# CITY OF ALBUQUERQUE

November 5, 2015

**RE: Holy Cross Townhomes | Grading and Drainage Plan | Stamp 9-24-15 (File: E19D021A)**

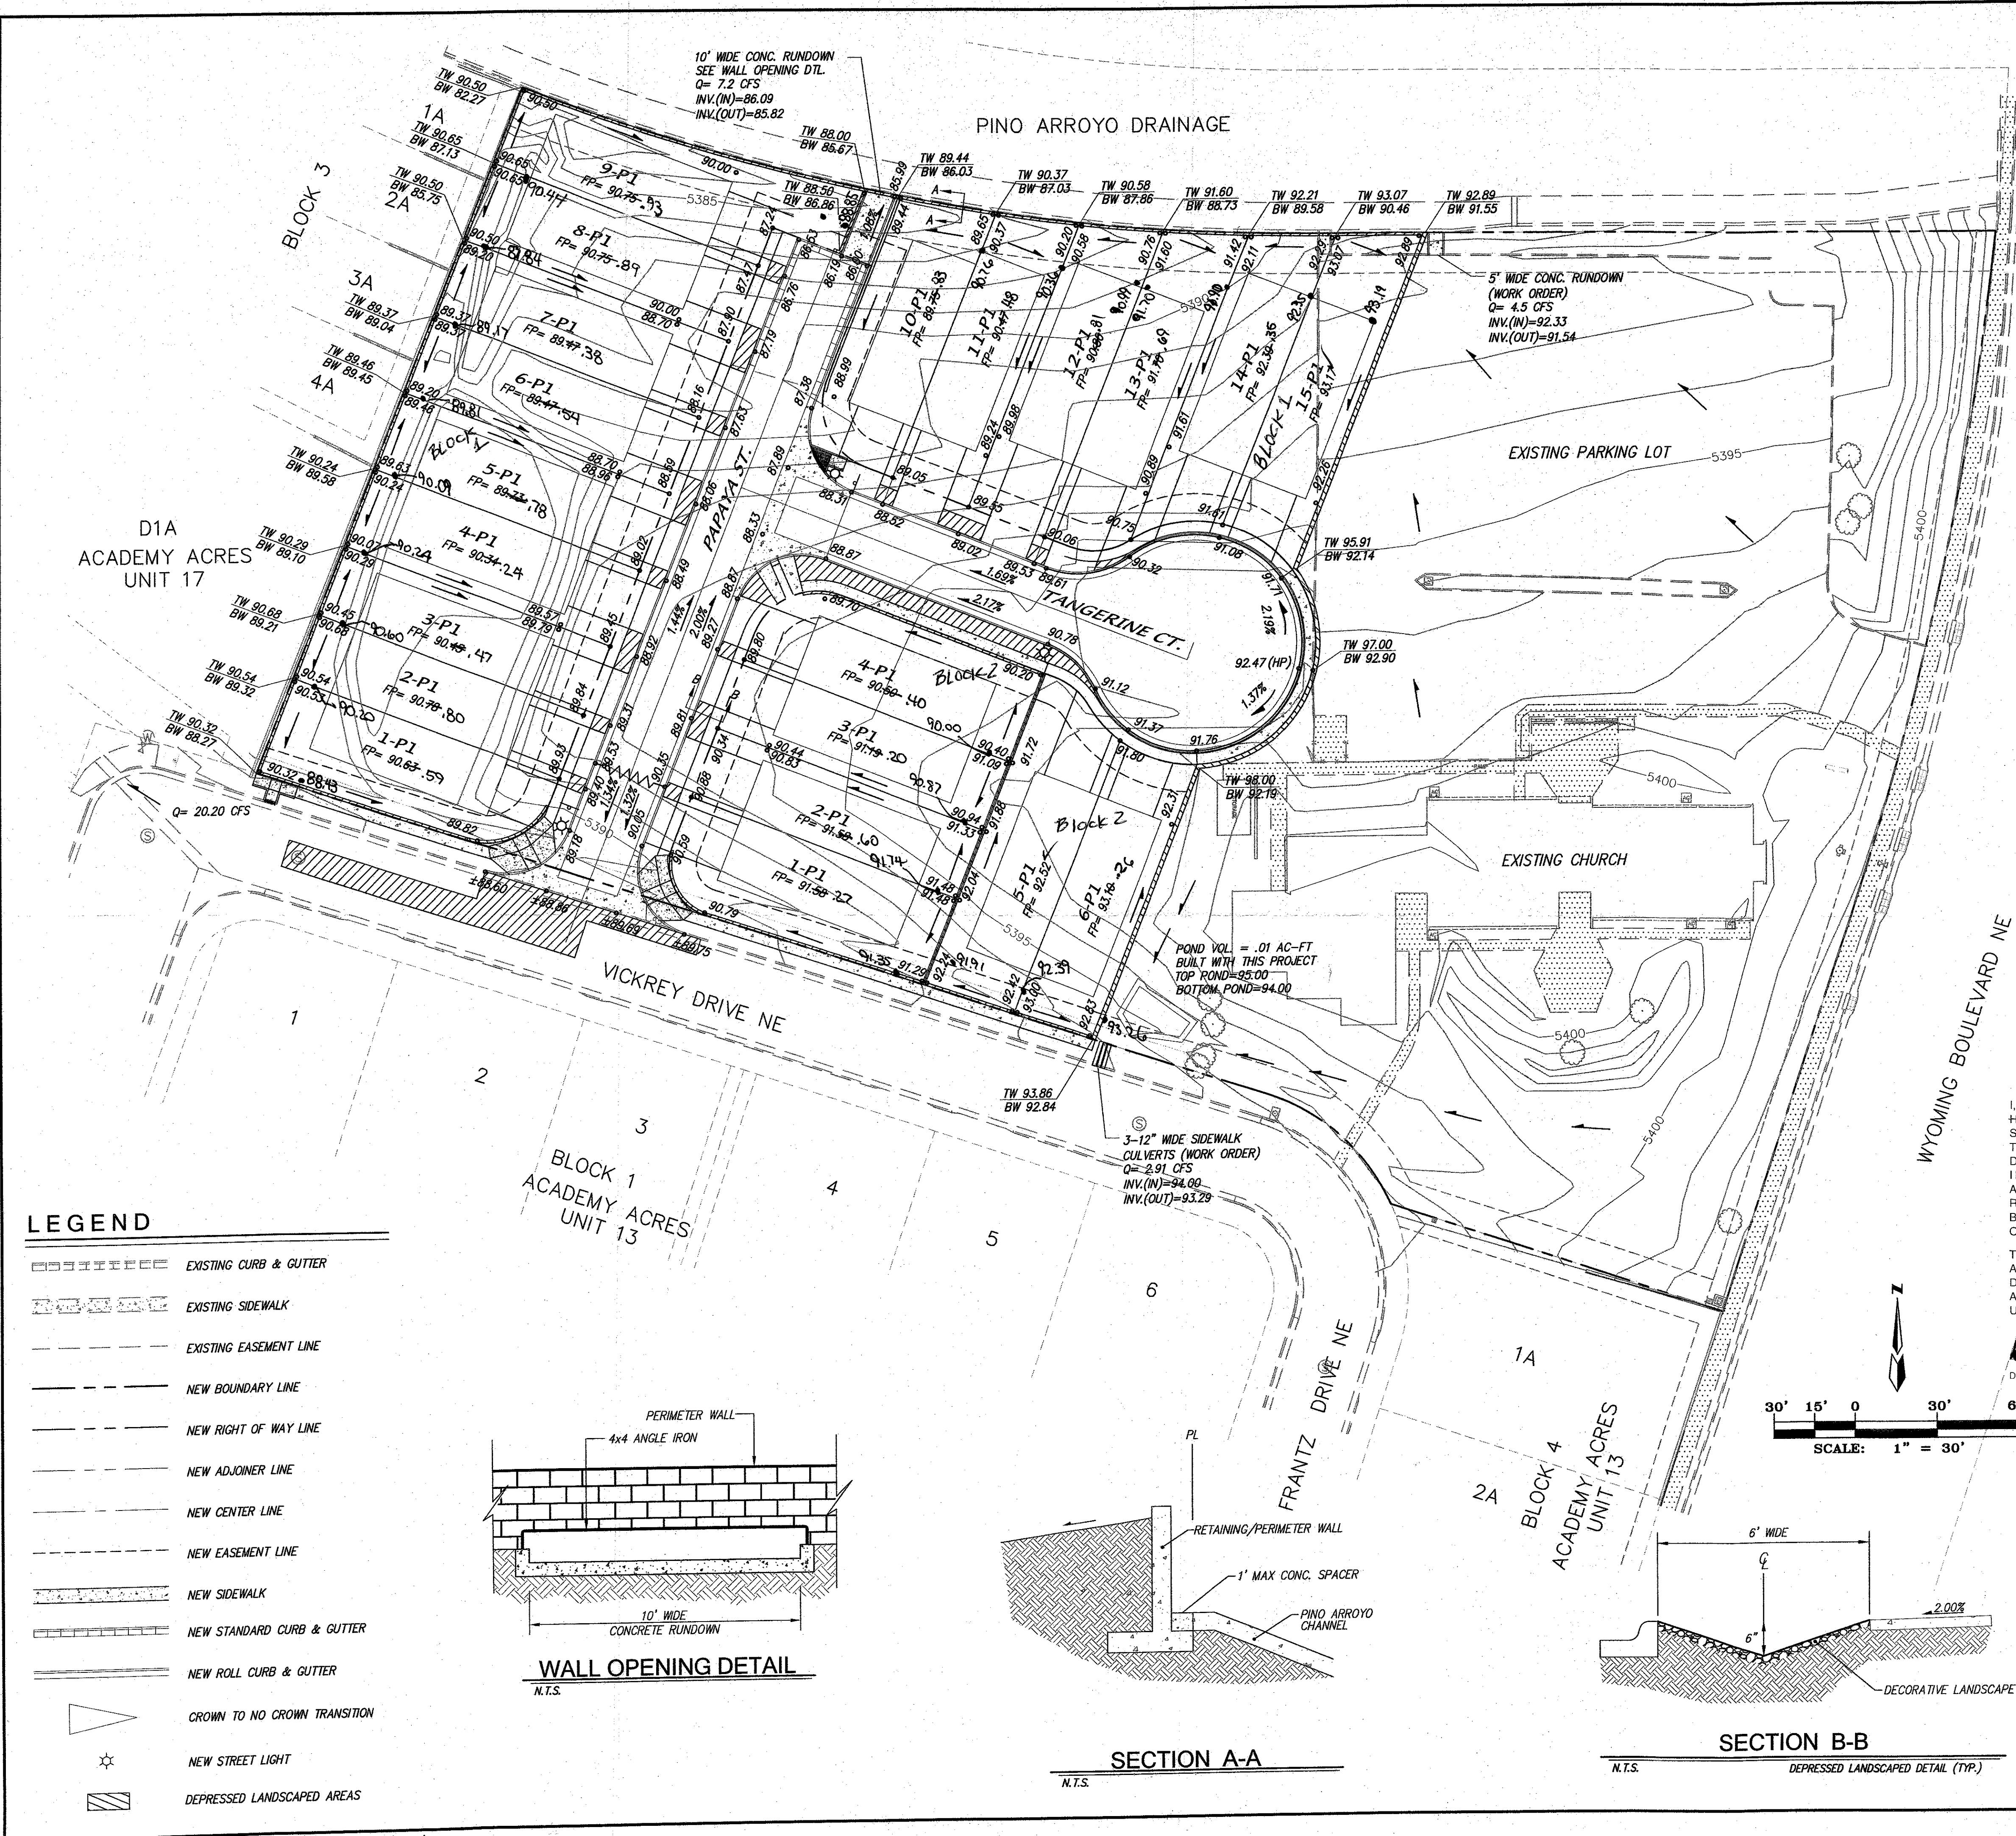
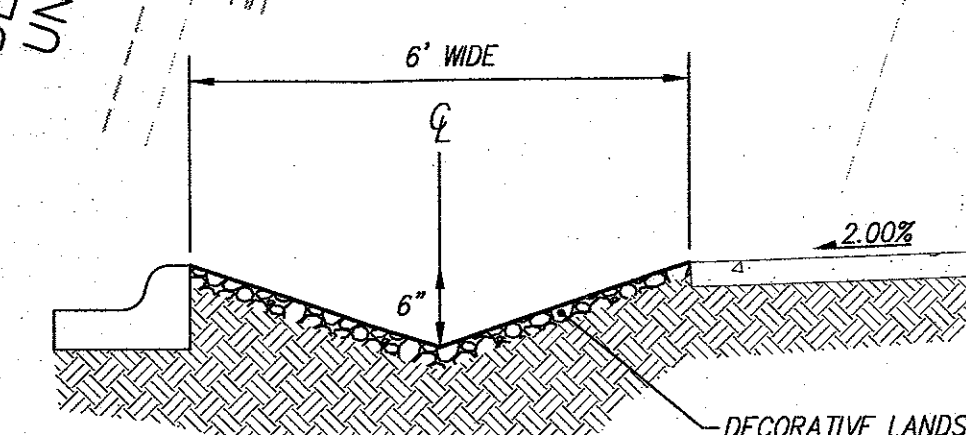
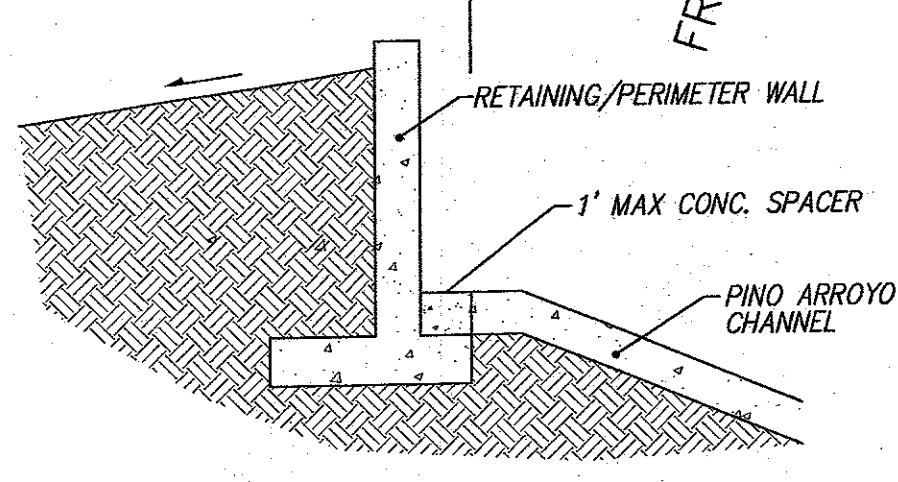
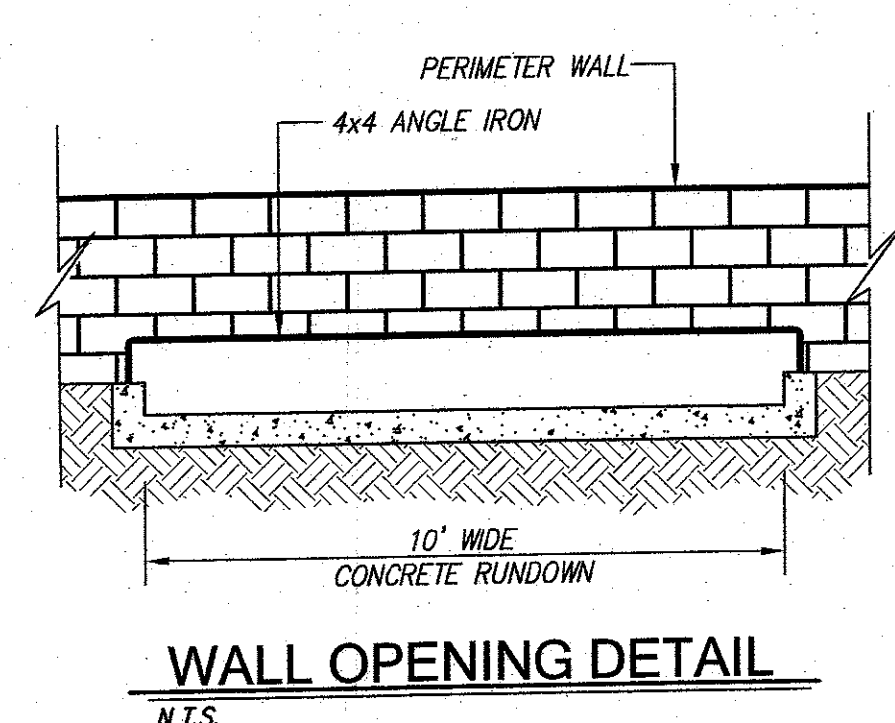
1. A first flush retention method needs to be included. It appears that the proposed plan included depressions between the sidewalk and the curb which could serve the purpose, but the drainage report states that the first flush requirement will not be addressed. If the depressions shown on the plan are to be used, a calculation of the first flush required vs provided needs to be included. If the depressions proposed between the sidewalk and the curb are not sufficient, then the design needs to include ponding areas on the individual lots.

3. Analysis Point 6 (AP6) in Vickrey Dr. is shown with a discharge of 10.06 cfs in Figure 1, but labeled with a discharge of 20.20 cfs at the valley gutter in the same vicinity on the Grading and Drainage Sheet.

4. Previous platting and design documents reference a rundown on the NW corner of the existing site. If this structure exists, it needs to be noted on the Sheet.

5. Show the dimensions of the wall opening on the design sheet.
6. ~~Section A-A and Section B-B appear to be 'typical' sections rather than actual sections.~~ AC
